From: Amanda Scholes on behalf of Planning.Responses
Sent: 01 June 2020 09:03
To: Planning Scanning
Subject: FW: LY/4/20/PL Barn at Broomhurst Farm, Lyminster

From: Info @ Folkes Architects <[REDACTED]>
Sent: 27 May 2020 16:10
To: Anita Gardner <Anita.Gardner@arun.gov.uk>
Subject: RE: LY/4/20/PL Barn at Broomhurst Farm, Lyminster

Proposed Barn Plans and Elevations

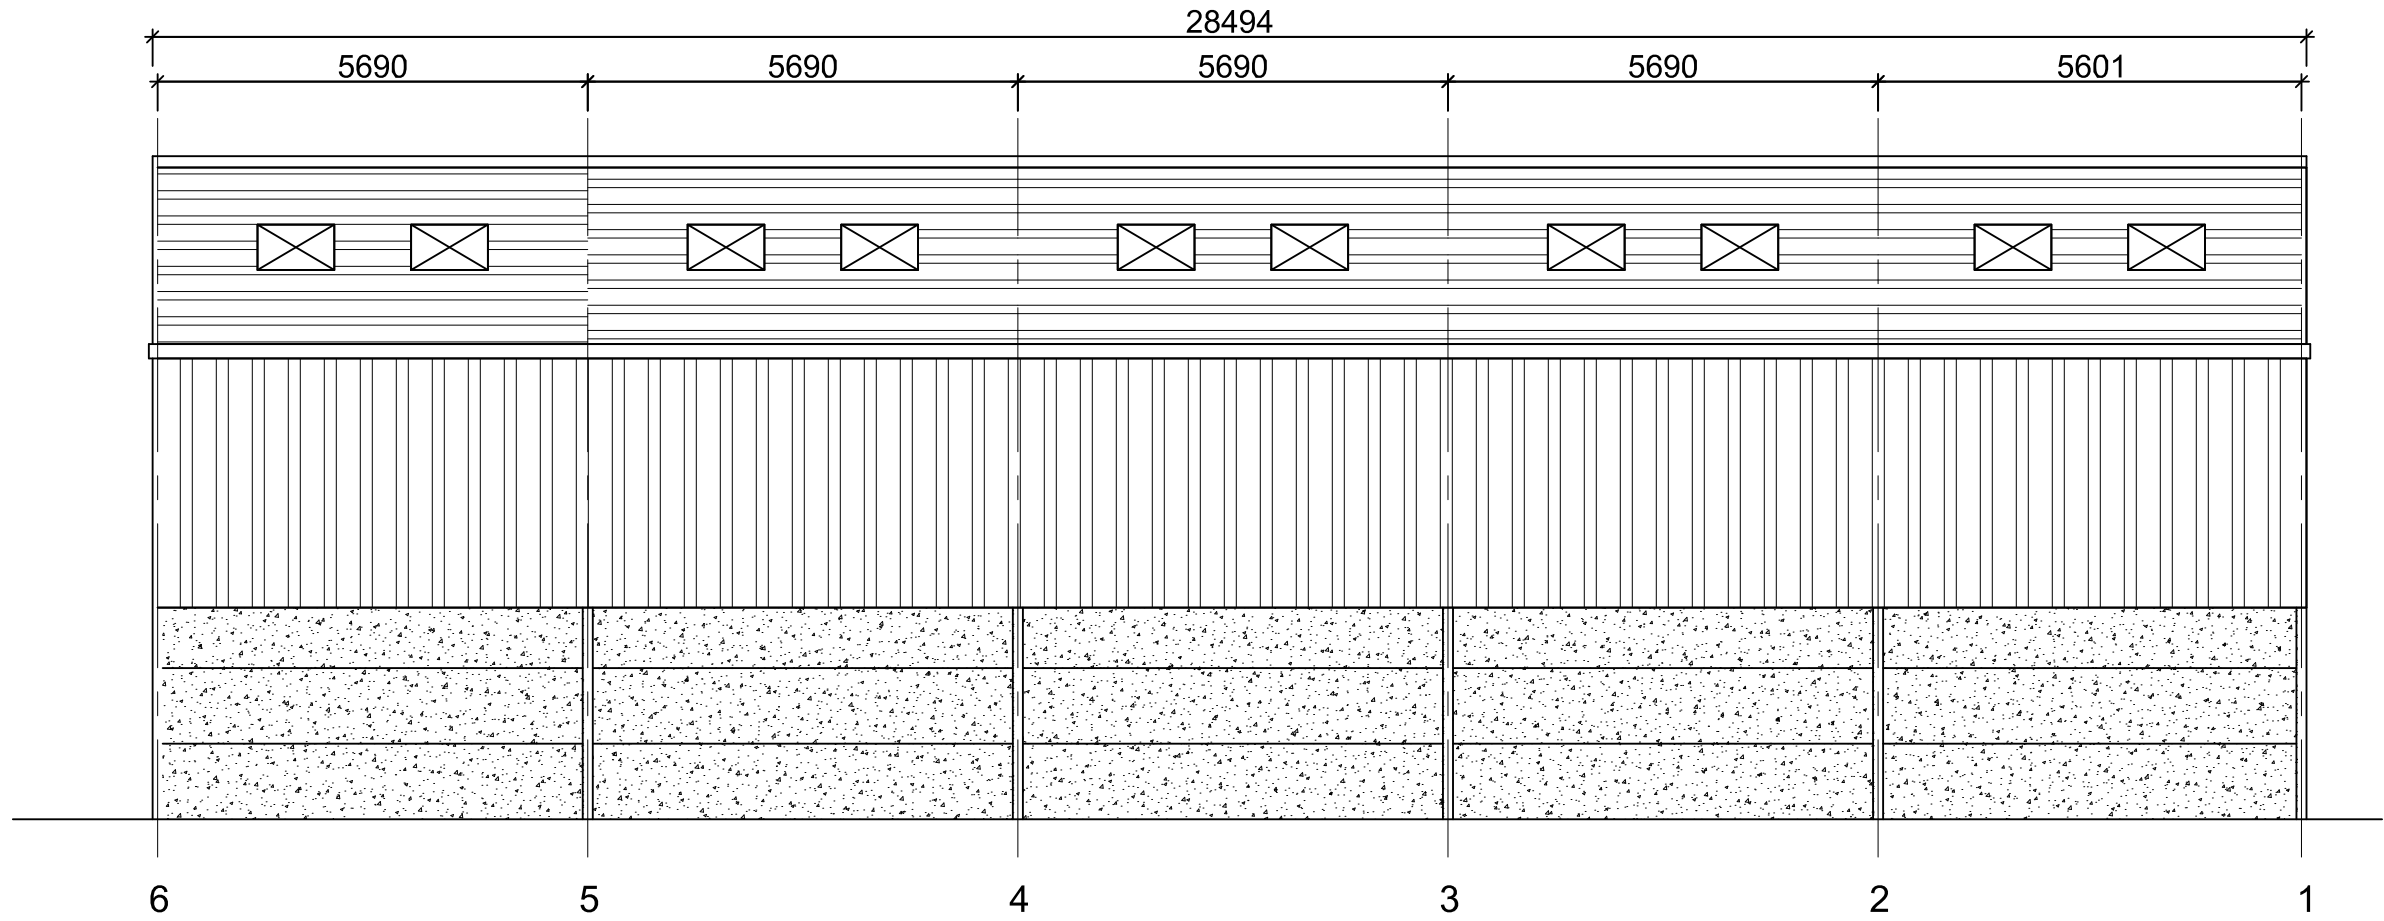
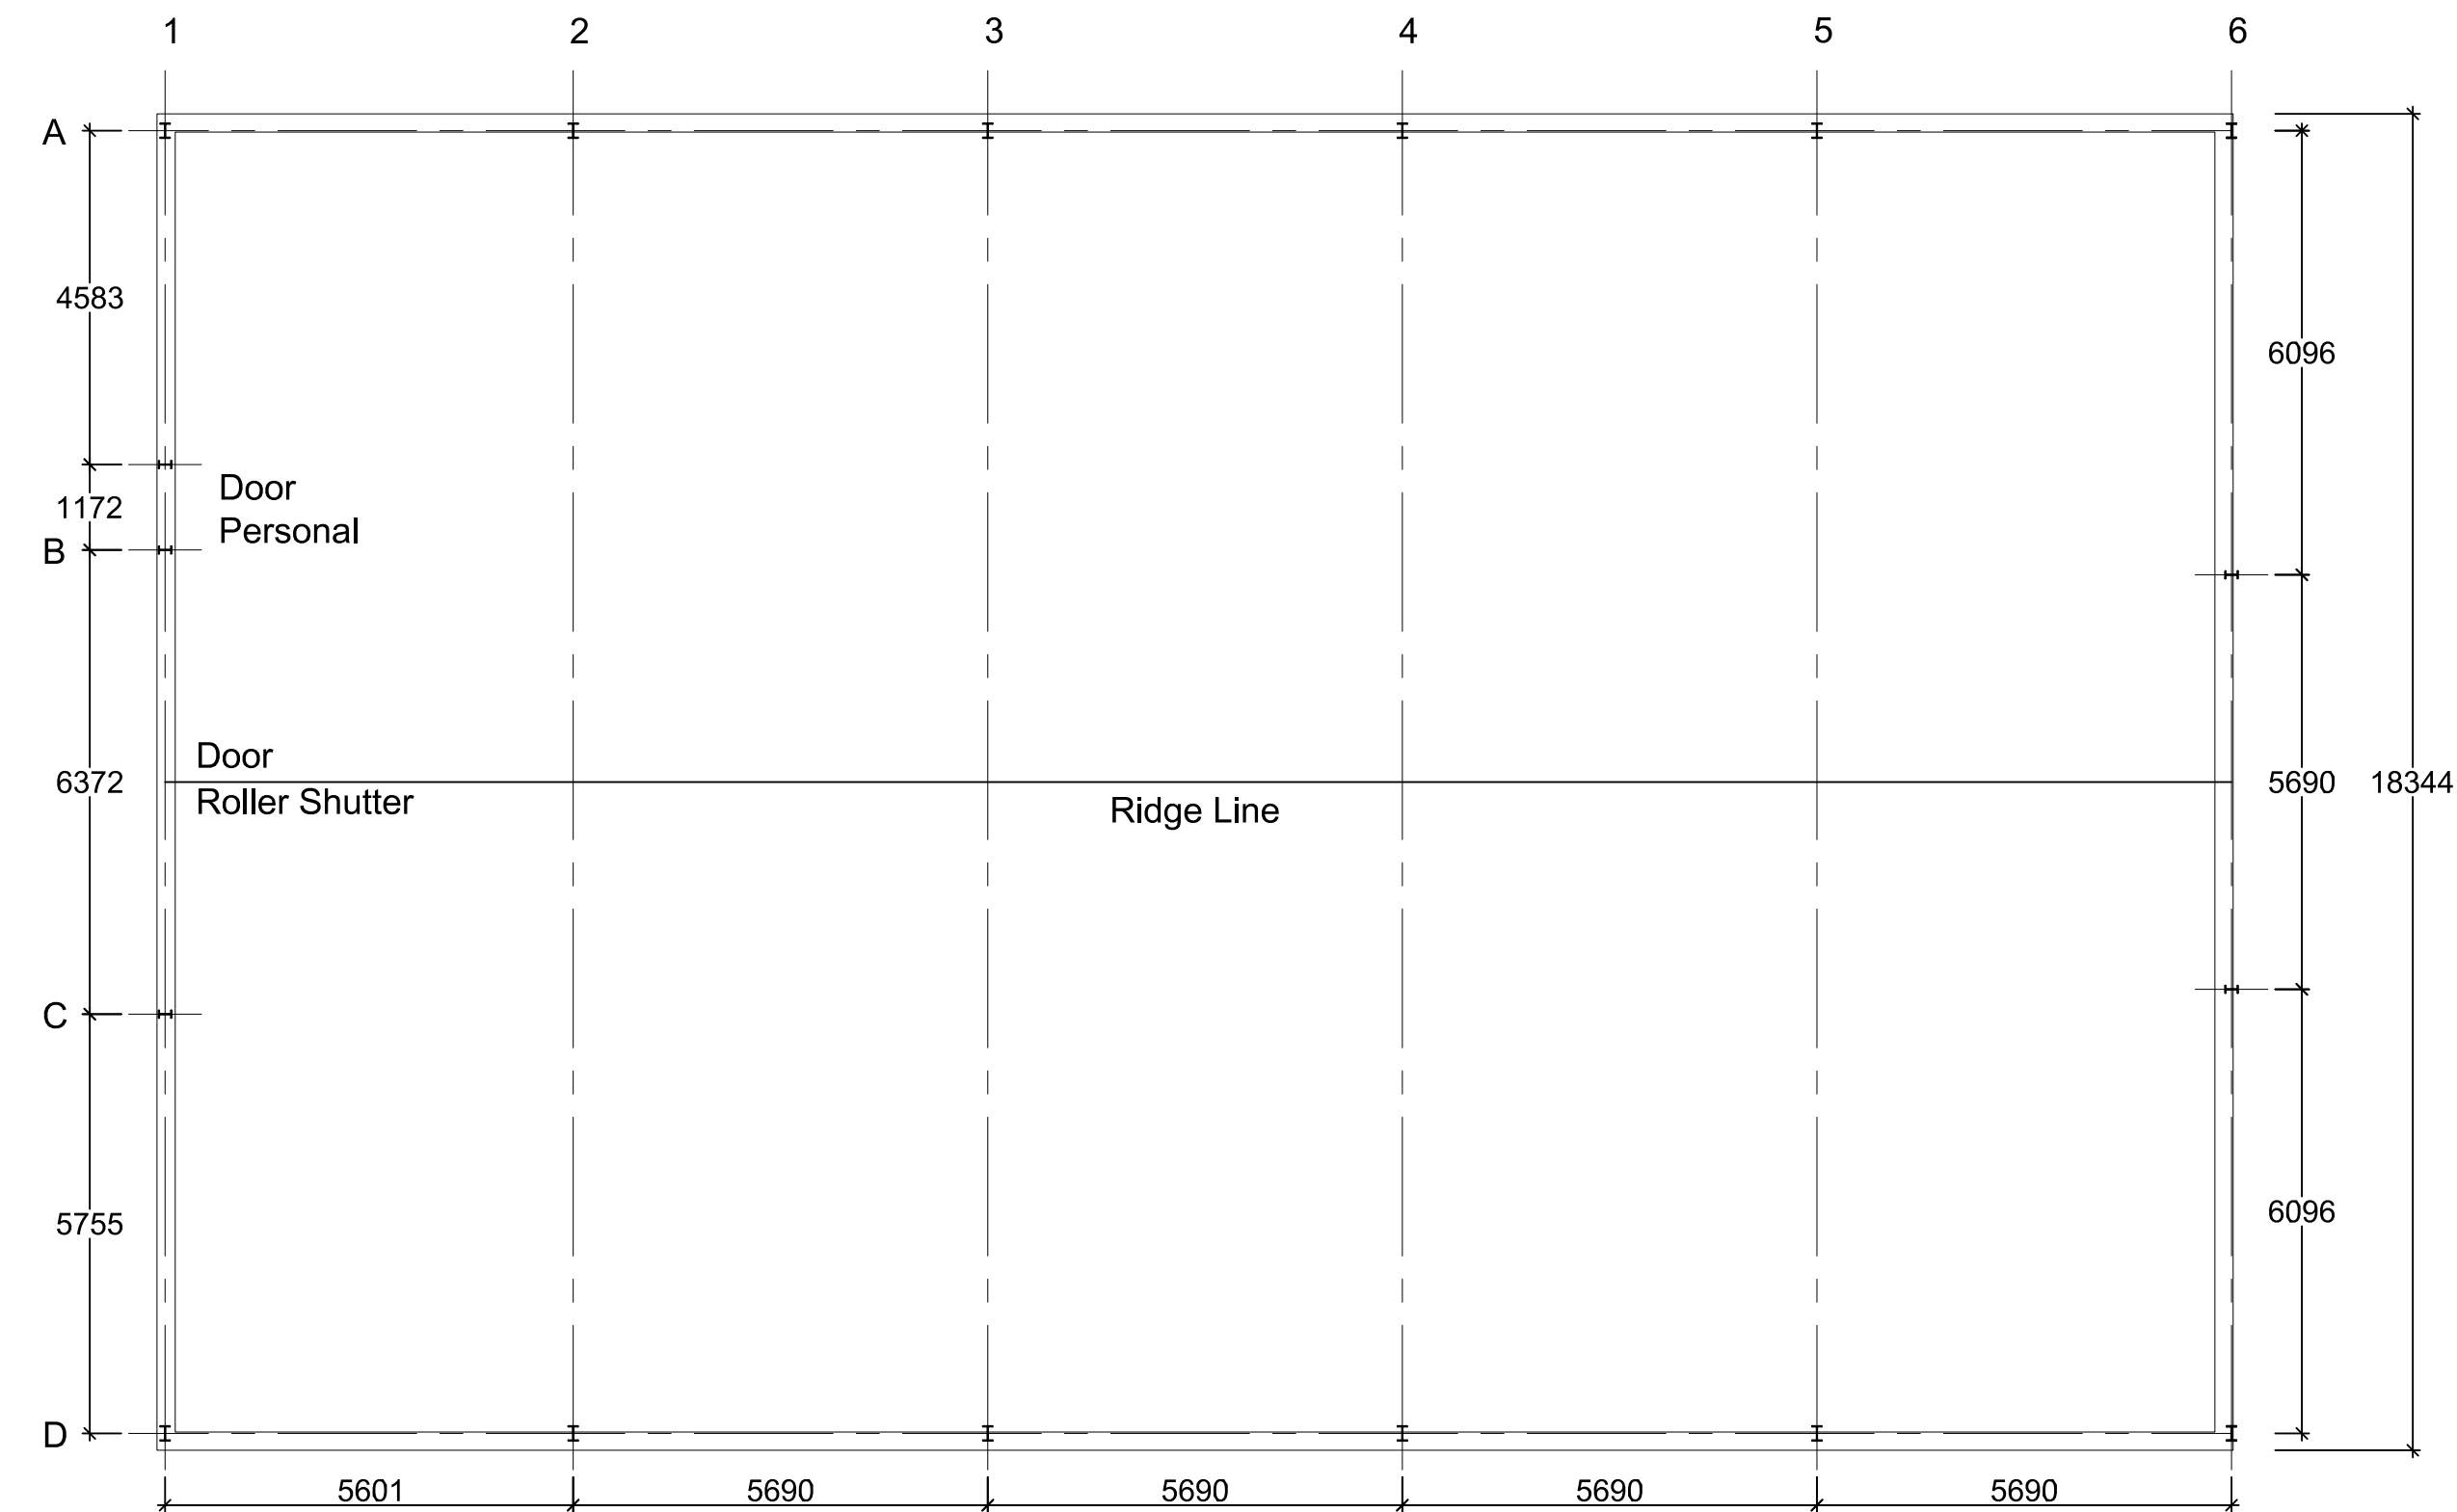
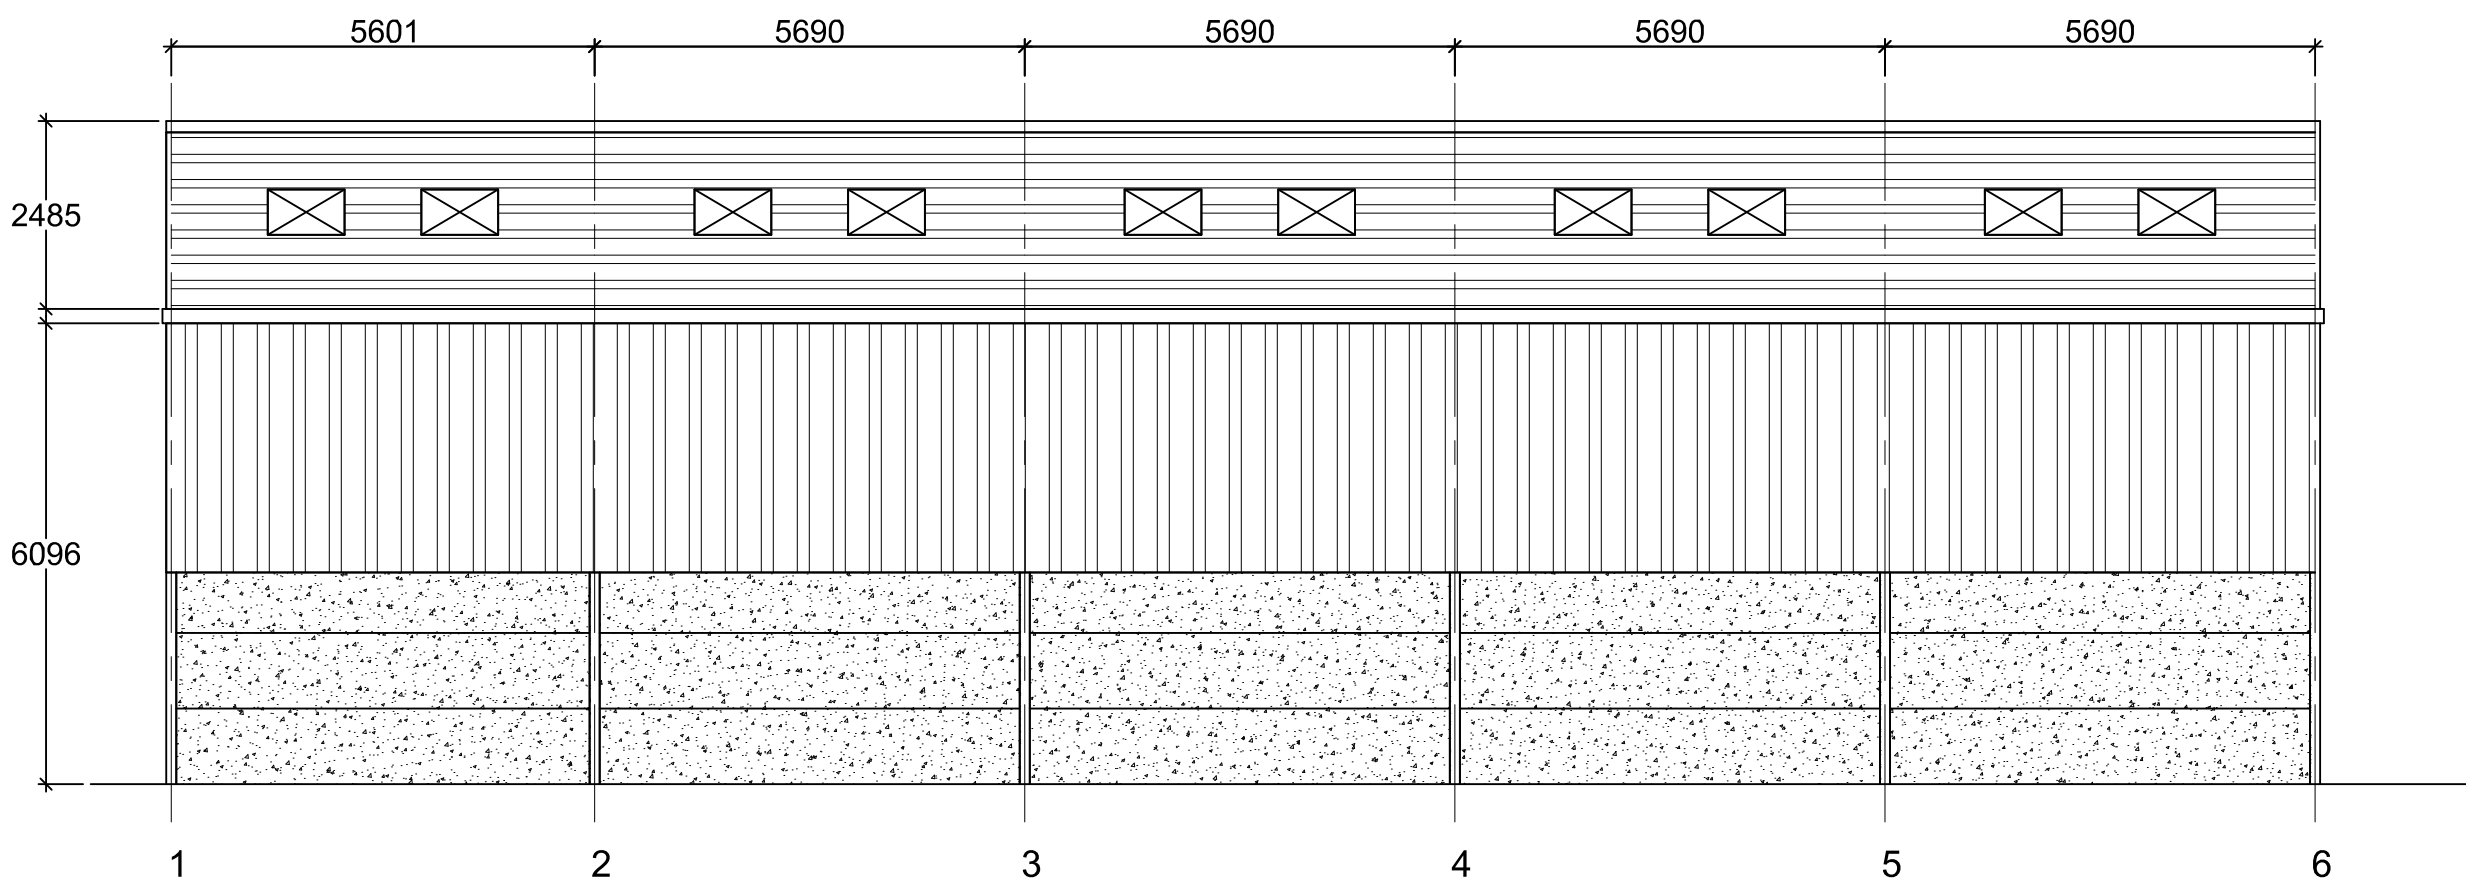
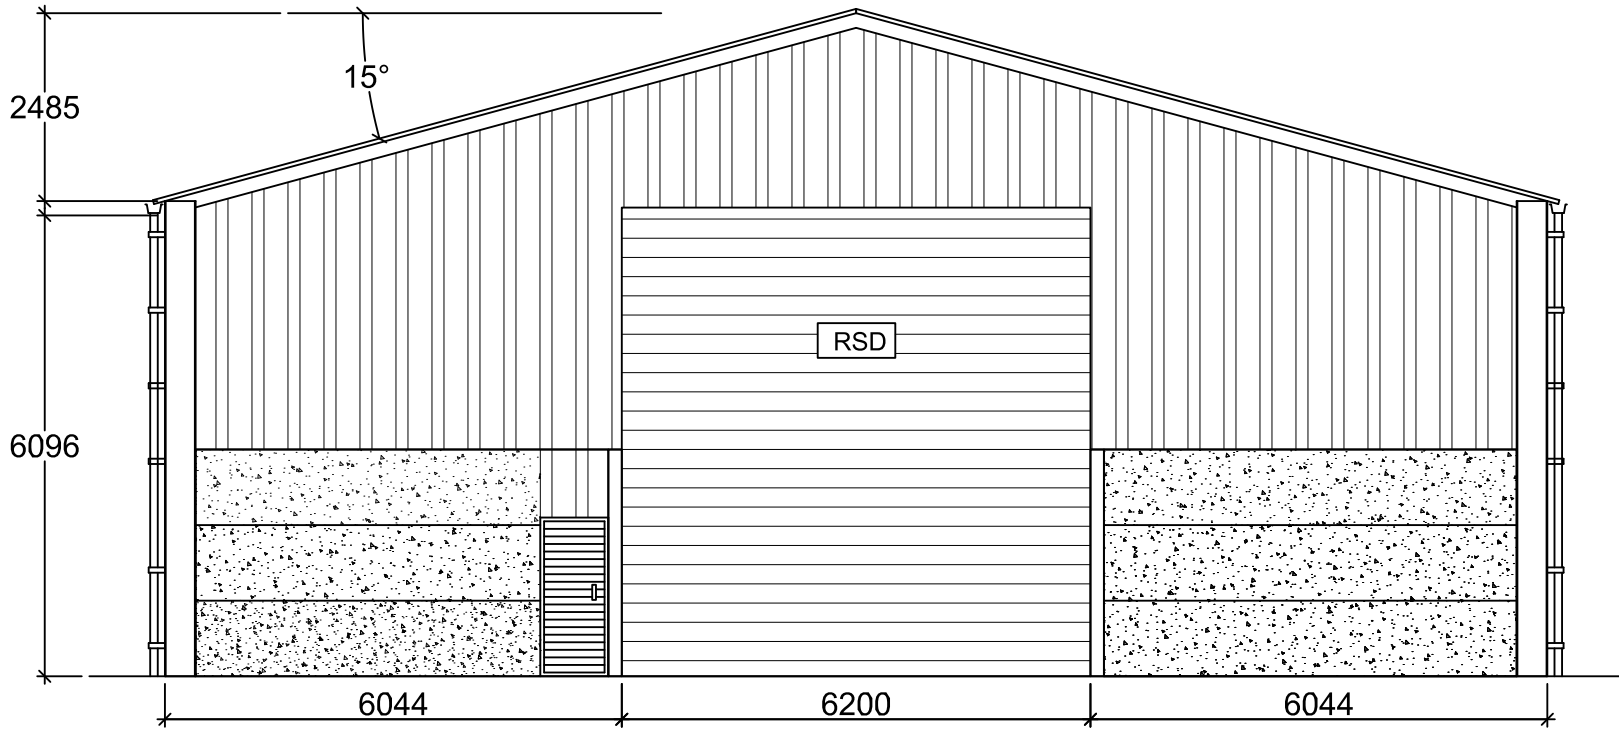
Is there no option to reduce the width/length of the building slightly so that tree planting can be included within the red edge? Or to move the building forward or sideways within the red edge? A reduction in size would help to address our concerns and those of the Parish.

Dear Mark,
I have reconsulted the Ecologist based on the details submitted and await her response. In the meantime I would appreciate receipt of a revised site plan indicating the provision of native planting along the south elevation of the barn.
Regards
Anita

I have spoken to our client and he is agreeable to planting native species to the south of the barn. Can this be treated as a planning condition?
